To: South Holland District Council Application Ref: H14-1286-25

Proposal: Erection of a mixed use commercial site for 11 industrial units & 4 office units

Location: **Land off Stephenson Avenue, Pinchbeck, Spalding, PE11 3SW**

ADDITIONAL INFORMATION REQUIRED

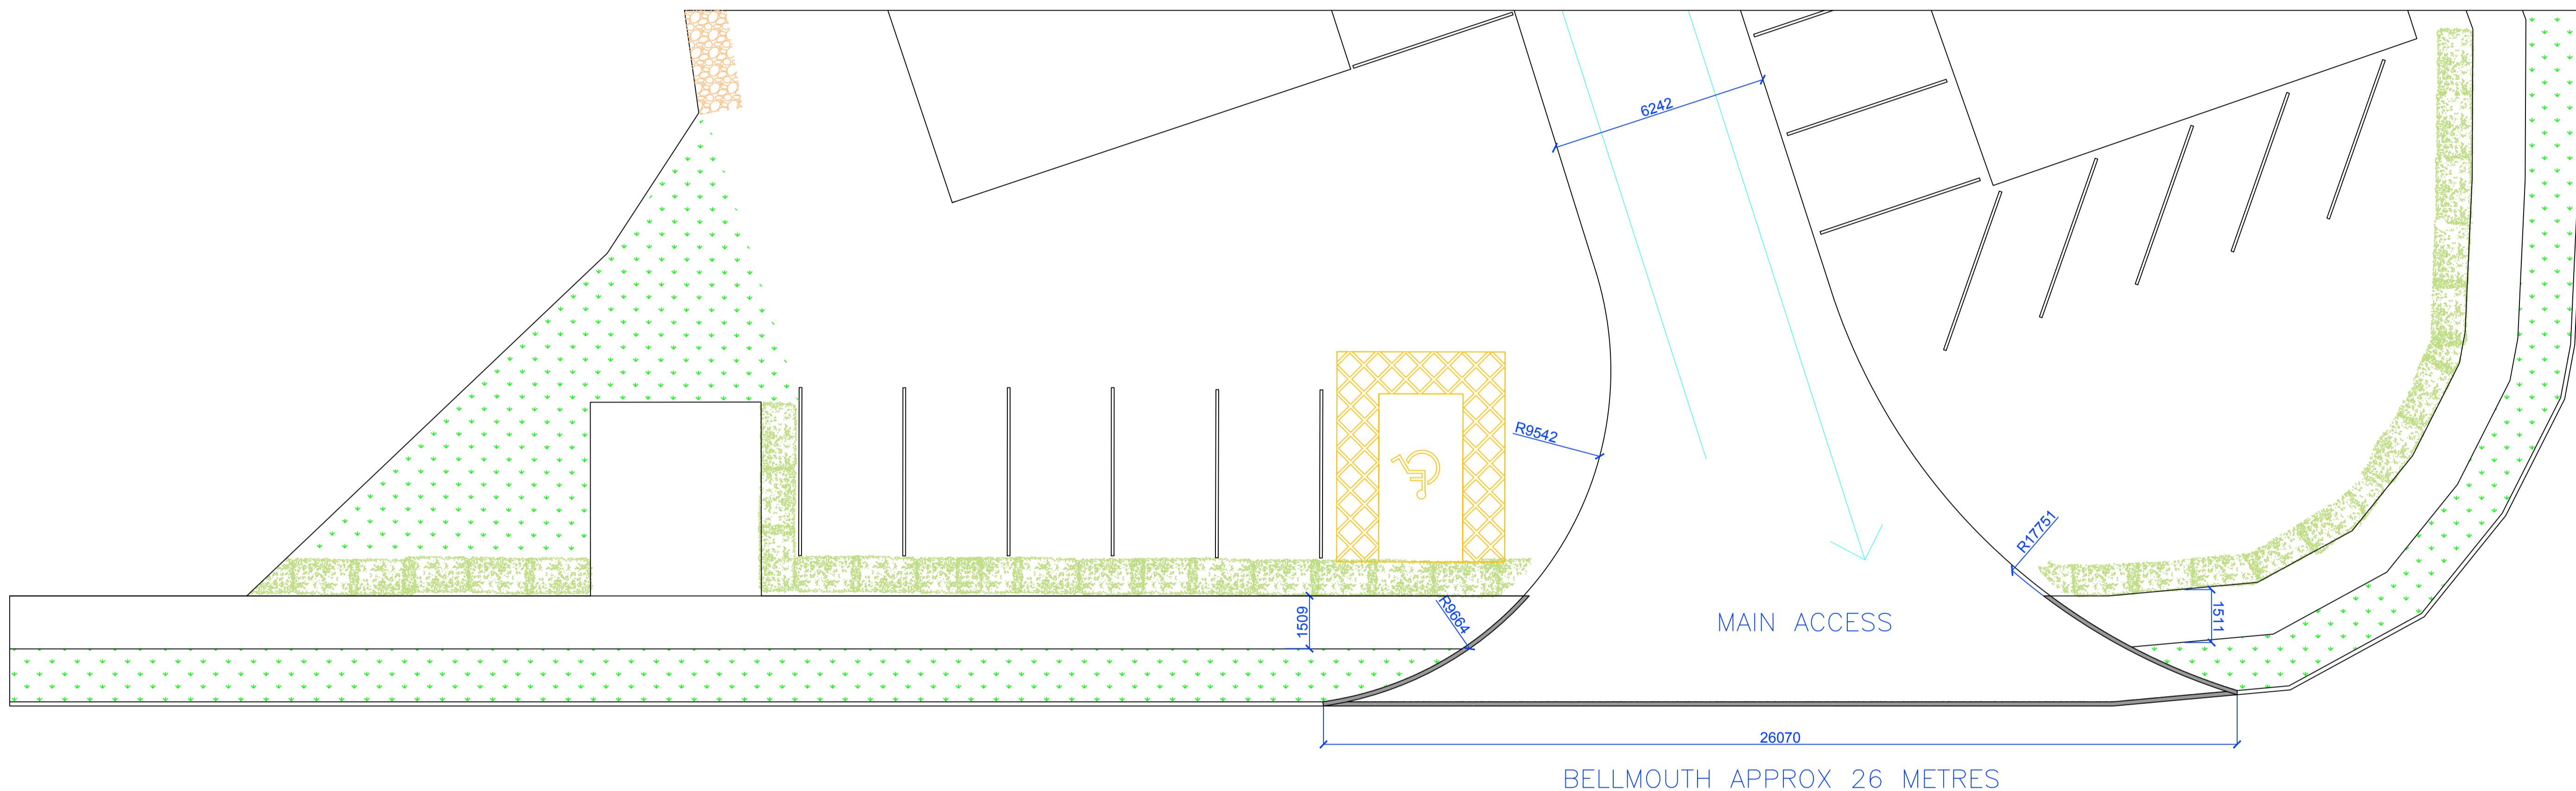
Please can you ask the applicant to clearly show on the site layout drawing the turning provision within the site for service/delivery vehicles and a fire tender to ensure they can enter and leave in a forward gear, in the interests of highway safety.
